RE: Hope Christian Elementary (Proj.
1008415) For your DRB Hearing on
09/01/10

5. **Project# 1008415**
10DRB-70191 MAJOR – SITE
DEVELOPMENT PLAN FOR
BUILDING PERMIT

10DRB-70191 MAJOR – SITE DEVELOPMENT PLAN FOR BUILDING PERMIT

Re: Hope Christian Elementary School Addition Project (1008415)

Designed: JM	Drawn: SPS	Checked: DMG	Sheet 1 of 4
Scale: 1" = 20'	Date: 8/27/2010	Job: A10032

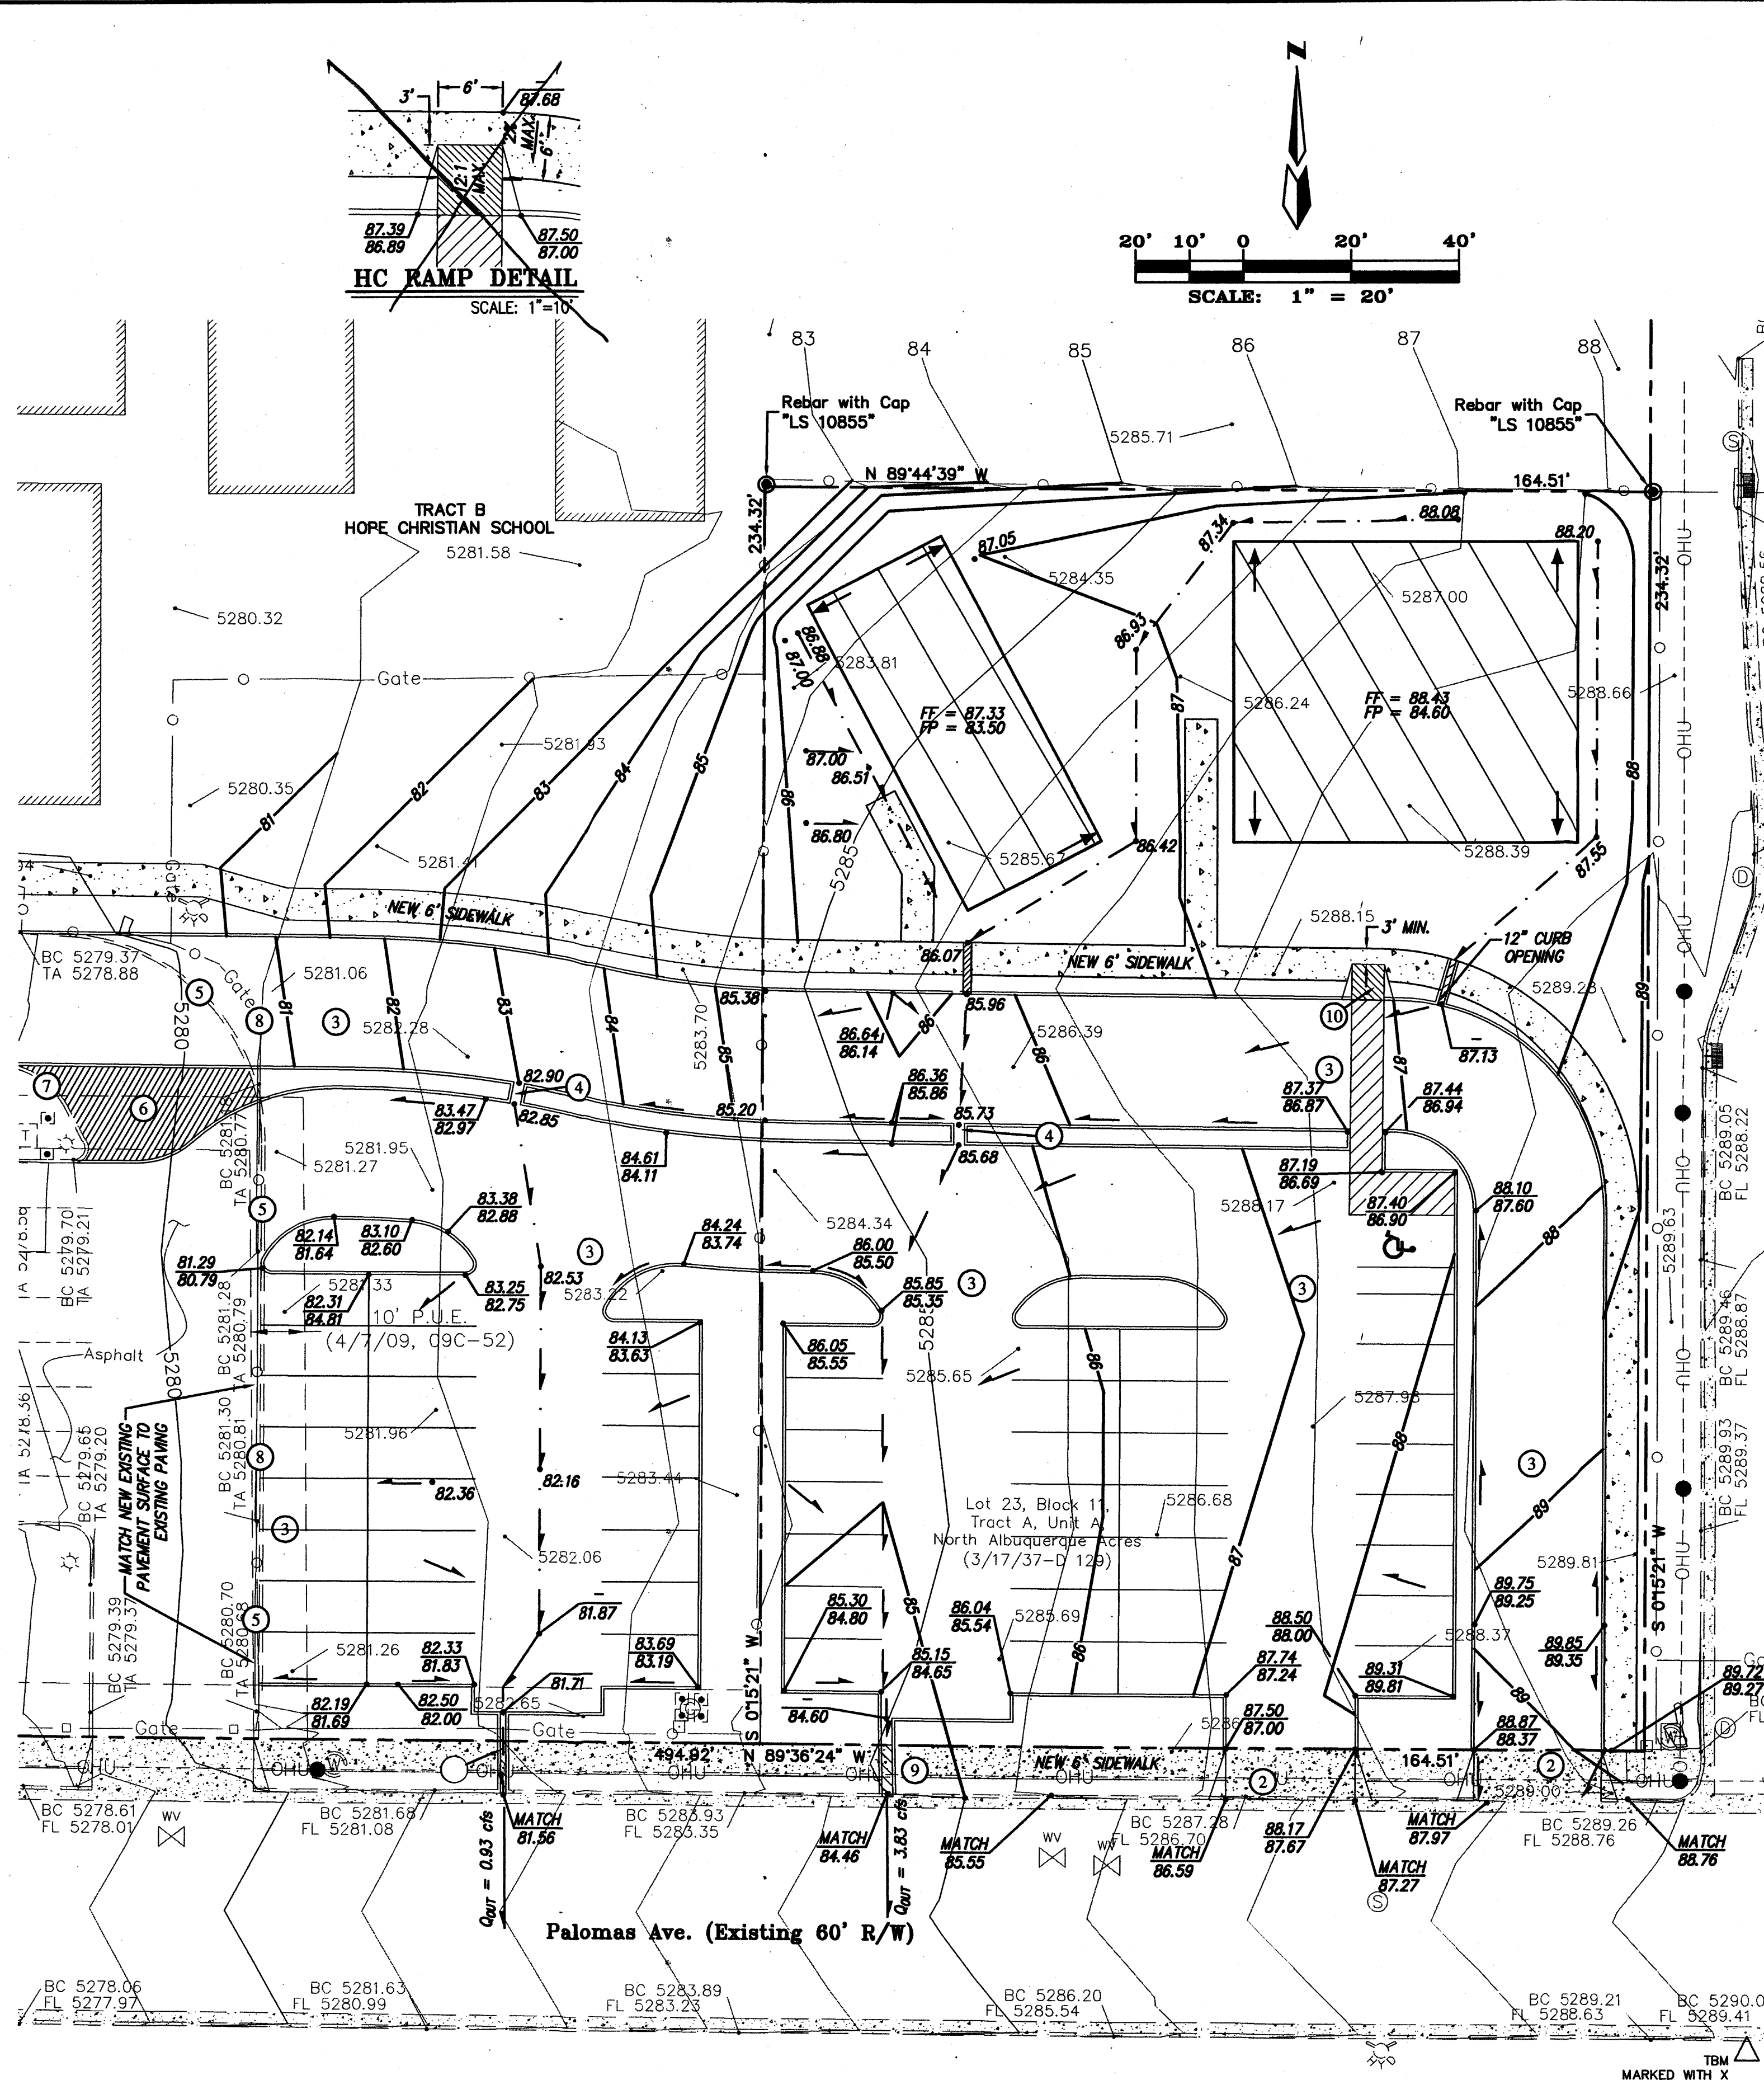
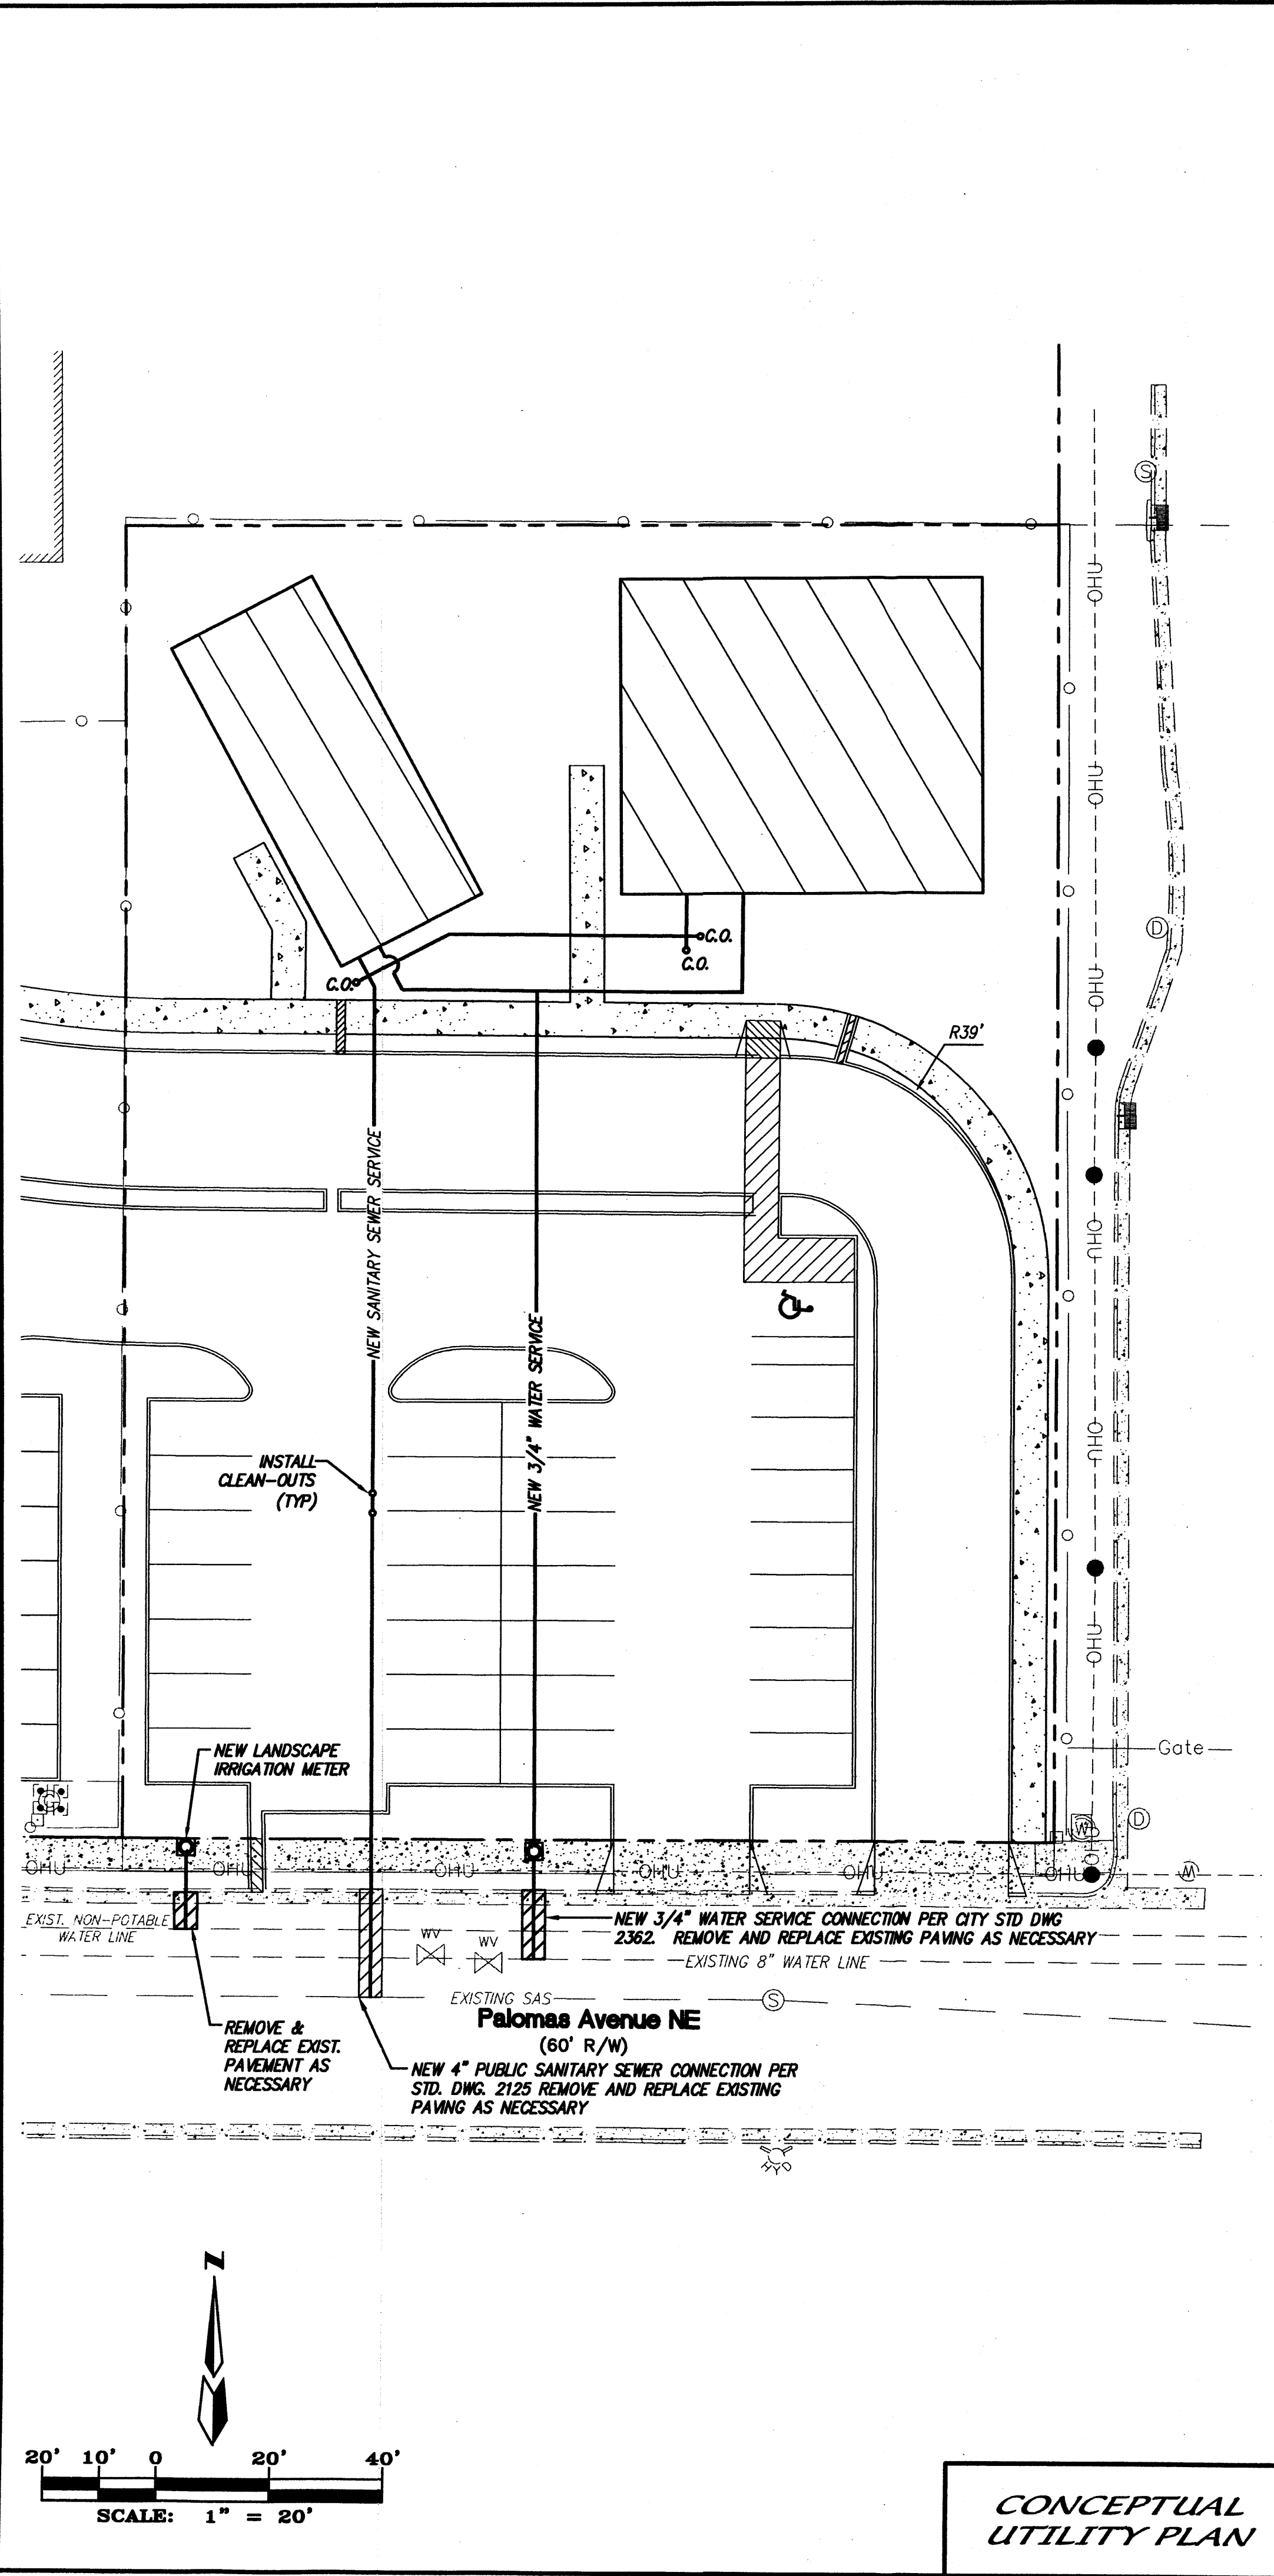
<p>M.R.G.C.D No Adverse Comments</p>
<p>OPEN SPACE DIVISION No comments.</p>
<p>CITY ENGINEER No adverse comments</p>
<p>TRANSPORTATION DEVELOPMENT Provide a copy of the cross lot access easement. Show the 6 foot wide, ADA accessible pedestrian pathway from the roadway to the building and from the handicapped parking spaces to the building. Show all ramps and provide details.</p>
<p>PARKS AND RECREATION No objection</p>
<p>ABCWUA No Adverse Comments</p>
<p>PLANNING DEPARTMENT This site plan needs to be discussed concurrently with the adjacent site plan (Proj. No. 1000539) and its proposed Administrative Amendment. The proposal for an isolated parking lot is not appropriate (refer to Section 4 of North I -25 sector plan); connection needs to be made to parking to the west. Landscape Plan and Site Plan need to conform with each other. Building elevations need to be specific, accurately labelled, and to scale, also, refer to comments from Zoning Enforcement.</p>

Then internal circulation route has been revised in accordance with your comments received during a meeting with you and Kristal Metro on August 12, 2010. Both the inside and outside vehicle circulation loops connect with adjoining Tract B of the school. Driveways on Palomas Ave. have also been changed to be consistent with our meeting discussion. A copy of the AA applied for on this adjoining property is included for your information. A draft of the paper access easement will be forwarded to you prior to the hearing of this application on September 1, 2010. As requested, a pedestrian connection has been extended around these vehicle routes to the east so that it can connect to public sidewalk at the SE corner of the site. The HC parking space has been relocated and a motorcycle parking space has been added as well.
